City of Mercer Island
Department of Community Development
Building and Land Use Planning Review

RE: Permit # 2203-002 - owner driven revisions
For proposed development at 4045 W Mercer Way
Parcel #: 362350-0395

This letter is to provide a brief synopsis of the property-owner driven changes to the building permit submission #2203-002 at 4045 W Mercer Way as instructed by Gareth Reece. The changes include the following:

A3.4

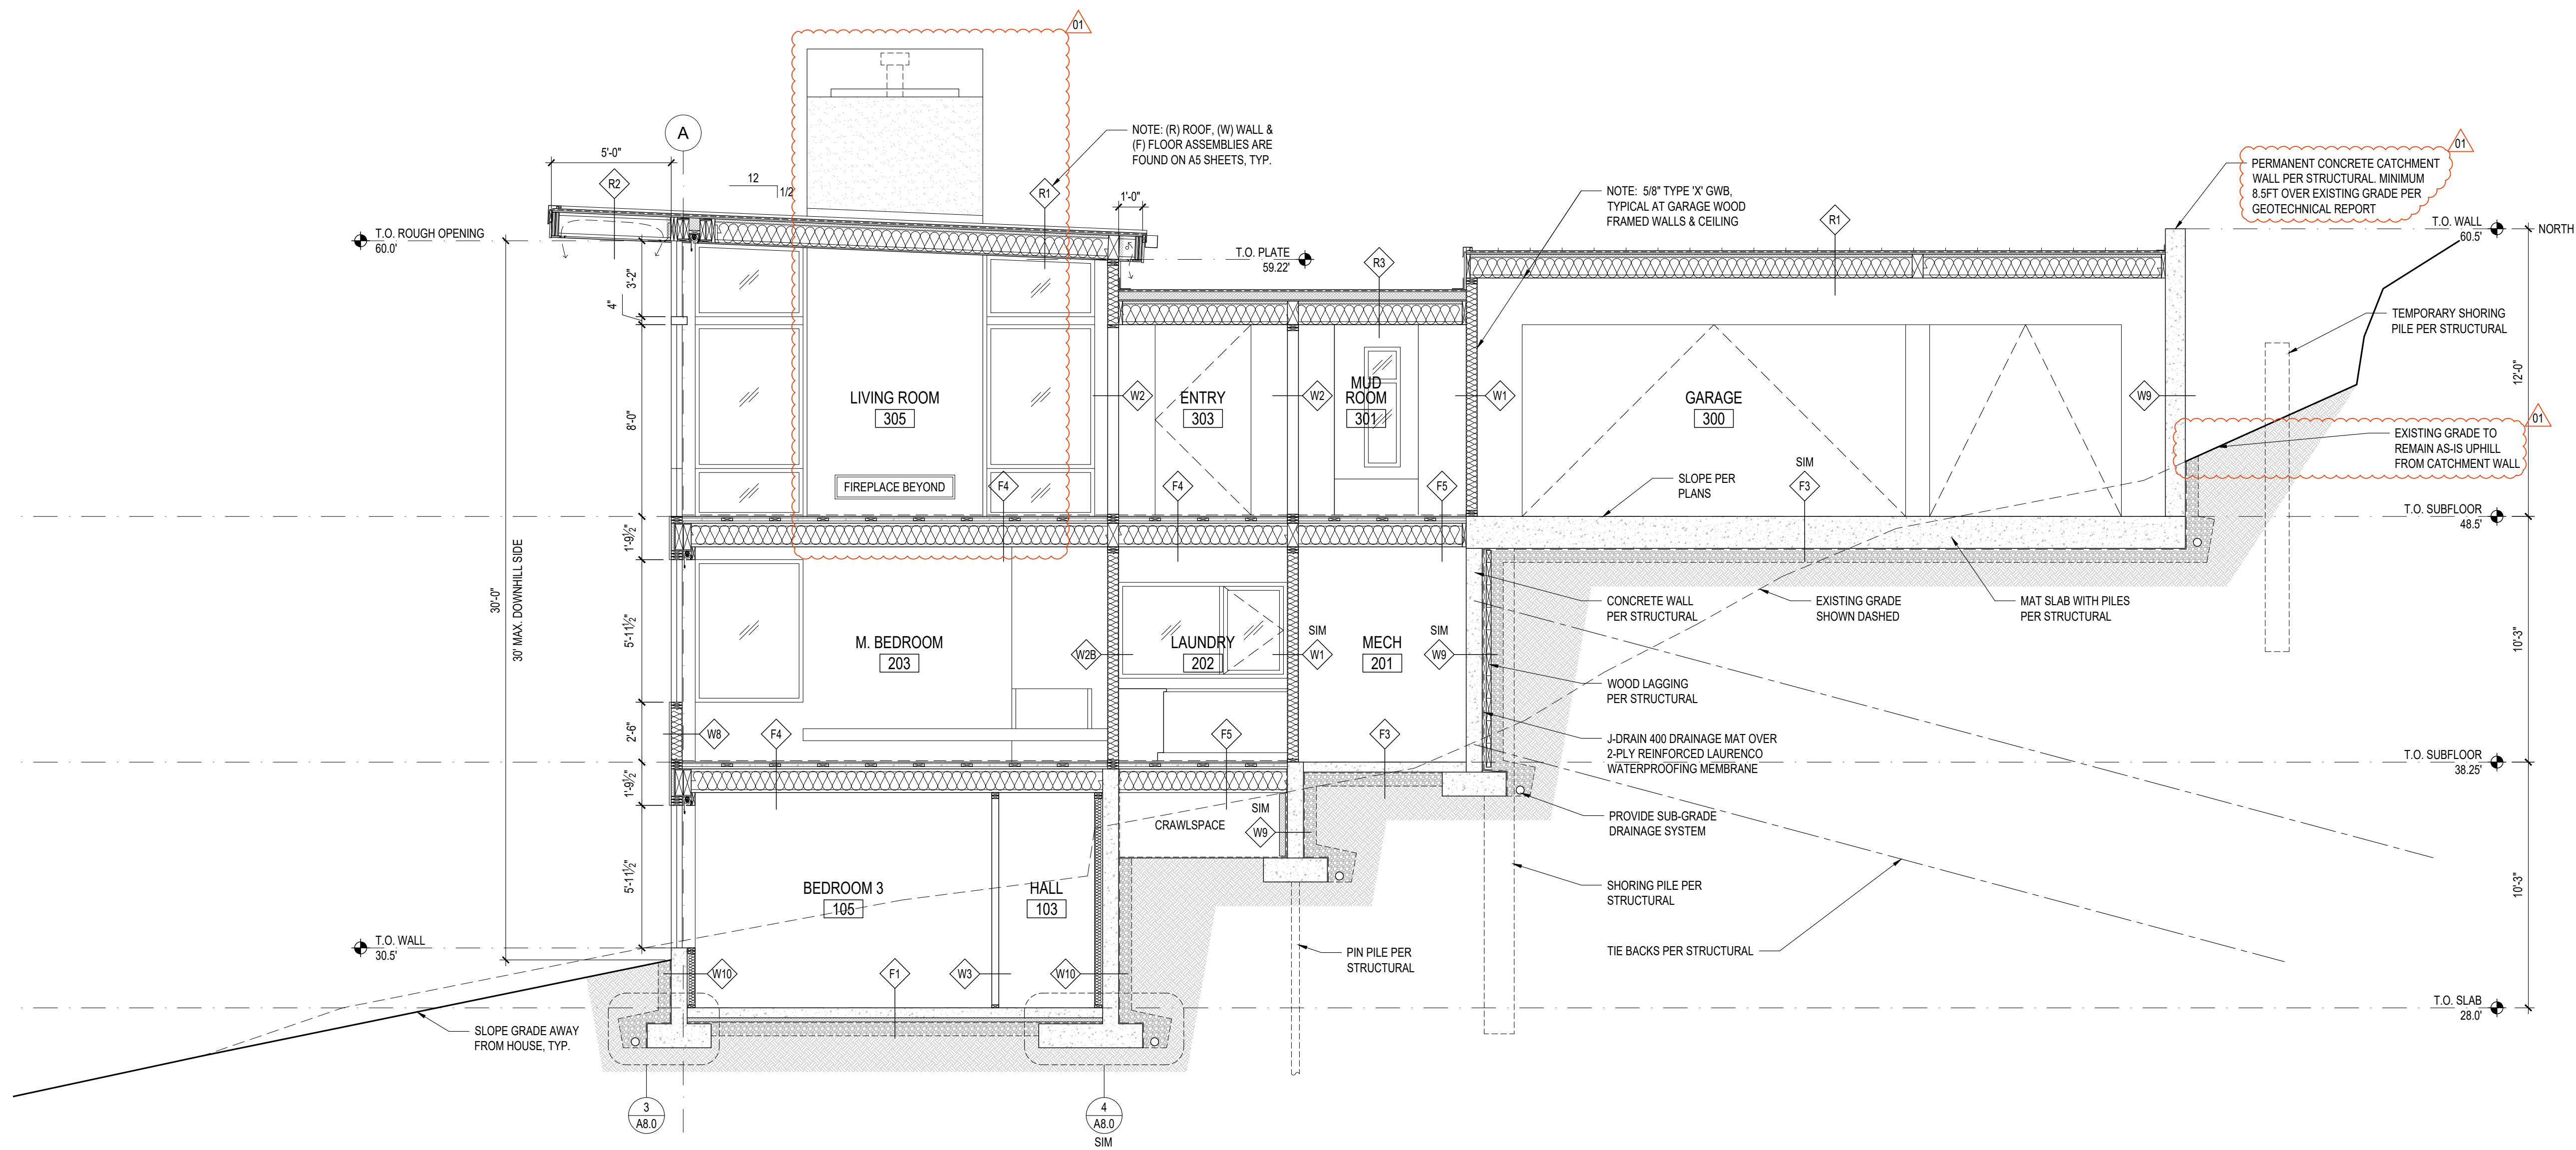
- 1) Revised fireplace location at the north end of the Living Room on the Upper Level Plan.
 - a) A traditional, gas fireplace with a chimney is proposed.
 - b) The plans, elevations and building sections have been updated and clouded.
 - c) The zoning code calculations for lot coverage and gross floor area have been updated and clouded.
- 2) A few windows have revised opening sizes or revised operability on the back side of the home.
 - a) The exterior elevations and opening schedule have been updated and clouded
